CITY OF ALBUQUERQUE

PLANNING DEPARTMENT – Development Review Services

**RE: Hurt Residence, Lot 11, Block 5 Unser Cliffs
Grading and Drainage Plan
Engineer's Stamp Date 7-7-14 (File: E10D025)**

Based upon the information provided in your submittal received 7-7-14, the above referenced submittal cannot be approved for Building Permit nor for Grading Permit until the following comments are addressed.

|  | <p>GRADING AND DRAINAGE PLAN</p> | <p>DATE 07-06-2014</p> |

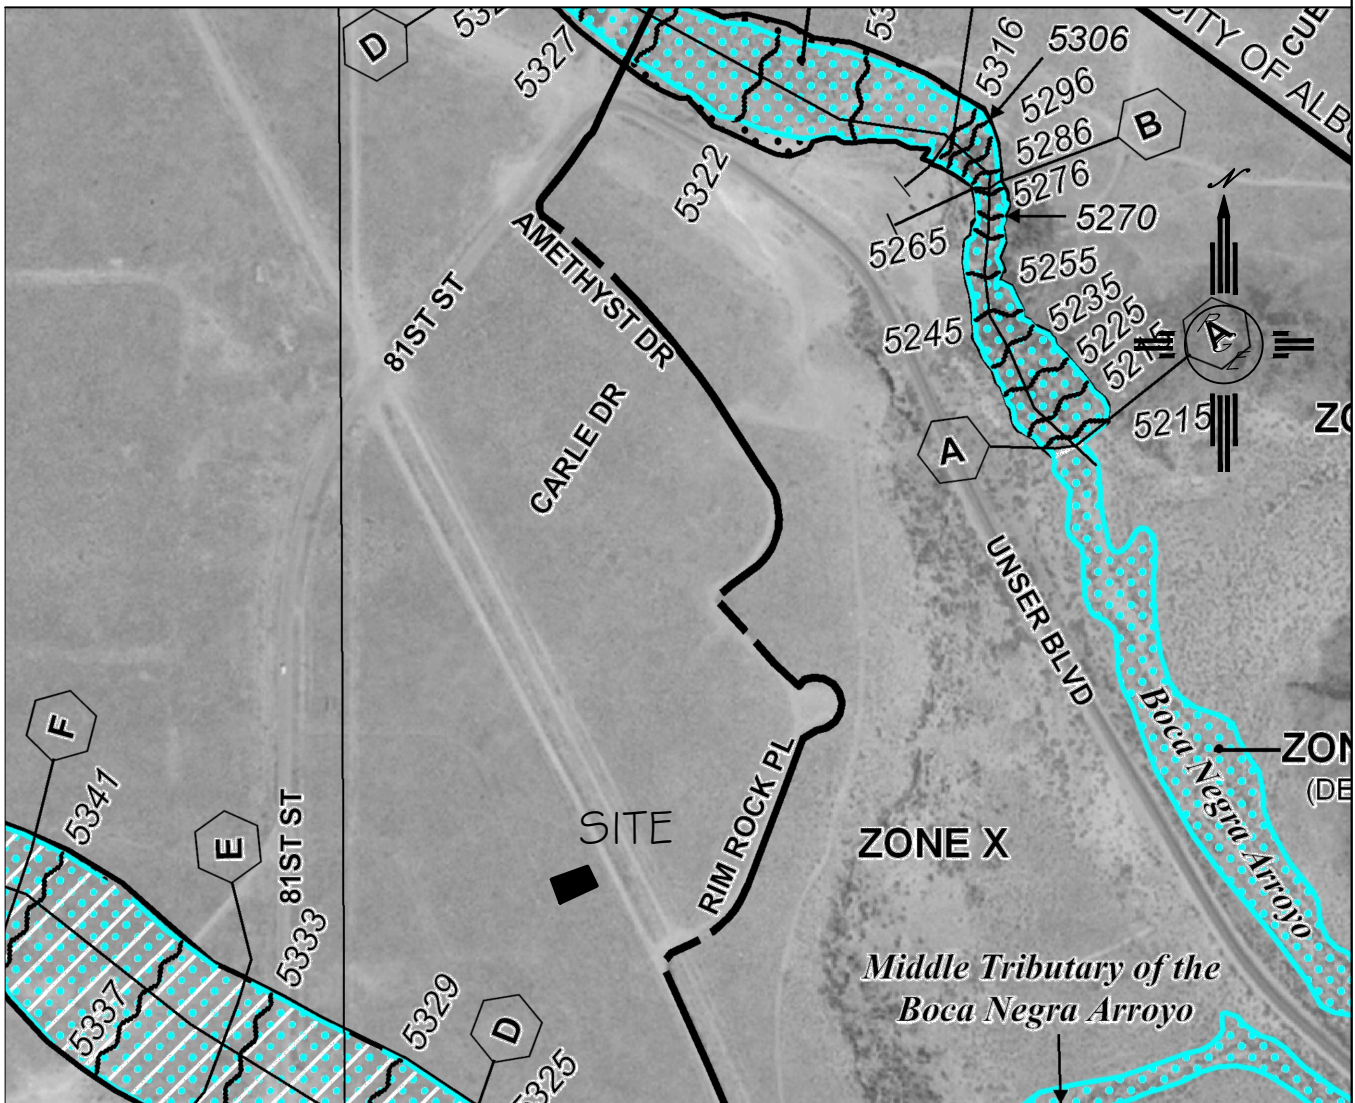
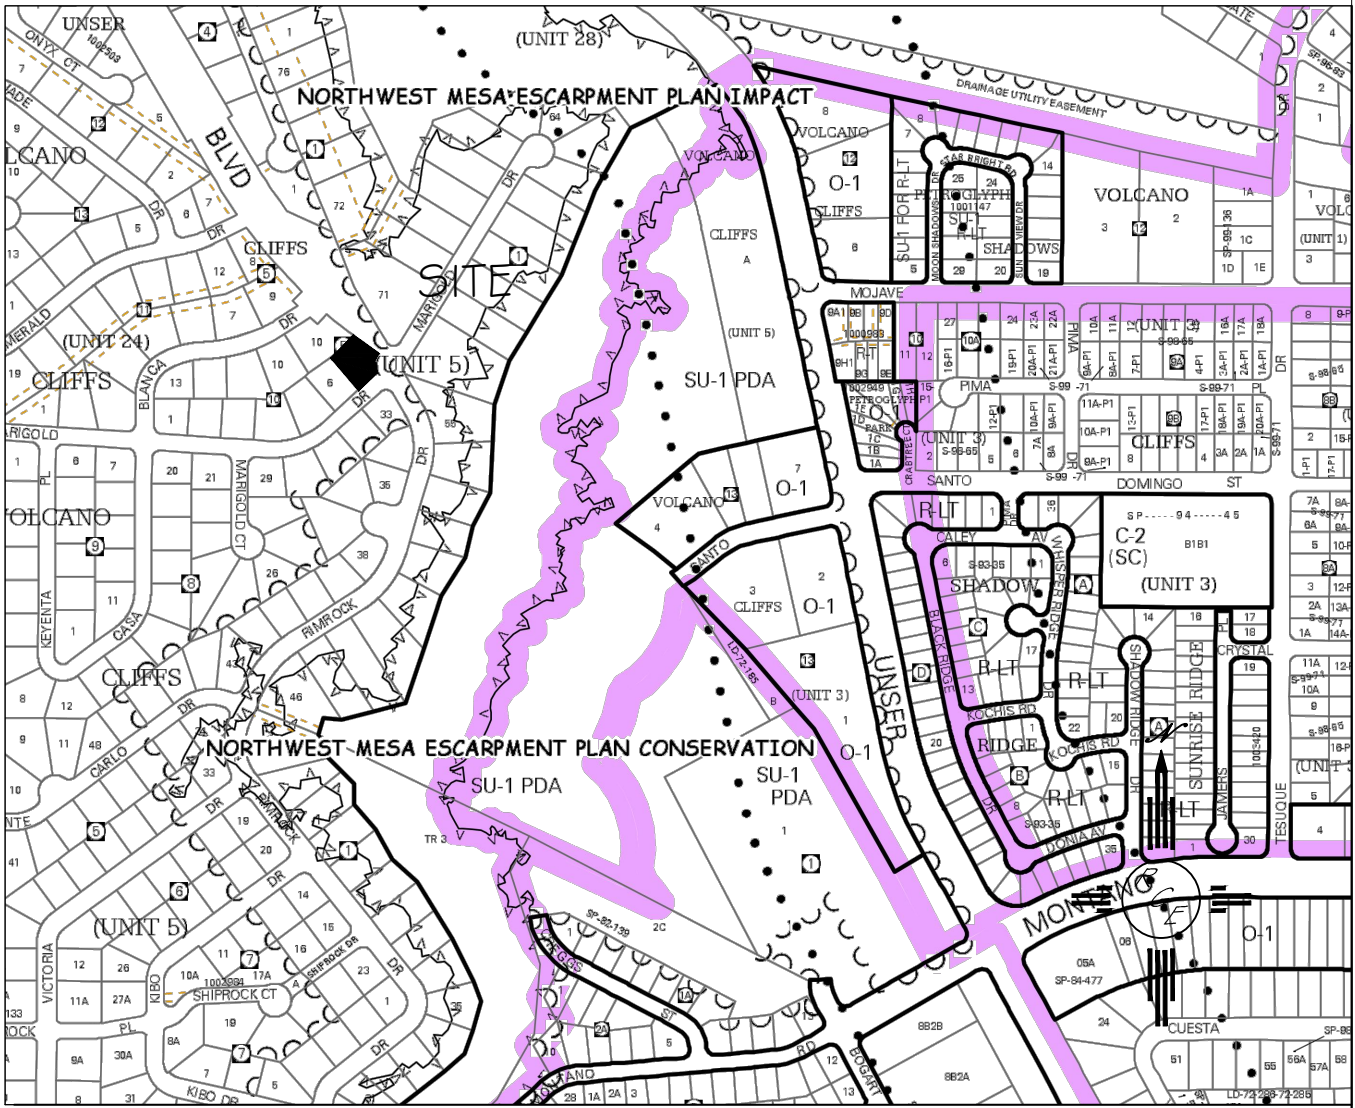
1. Existing contours are too light to be seen
2. Indicate Zone Atlas Coordinates
3. Provide Existing and proposed drainage calculations.
4. Provide Summary or Narrative explaining drainage Scheme
5. Quantify offsite flows, if any
6. Indicate Contributing Area
7. Any easements?
8. As discussed, turned CMU Block only to occur on discharge side of property. Plan states a rundown collects runoff, and conveys to Public Storm Drain. Are there Curb cuts in Casa Blanca Cul-de-sac to convey flow to inlet? If there a rundown or a pedestrian path? Show section of rundown.
9. Consider draining to inlet at the end of Marigold with water harvesting pond in front. FL Elevations in Marigold Cul-de-sac are lower than the FP EL.
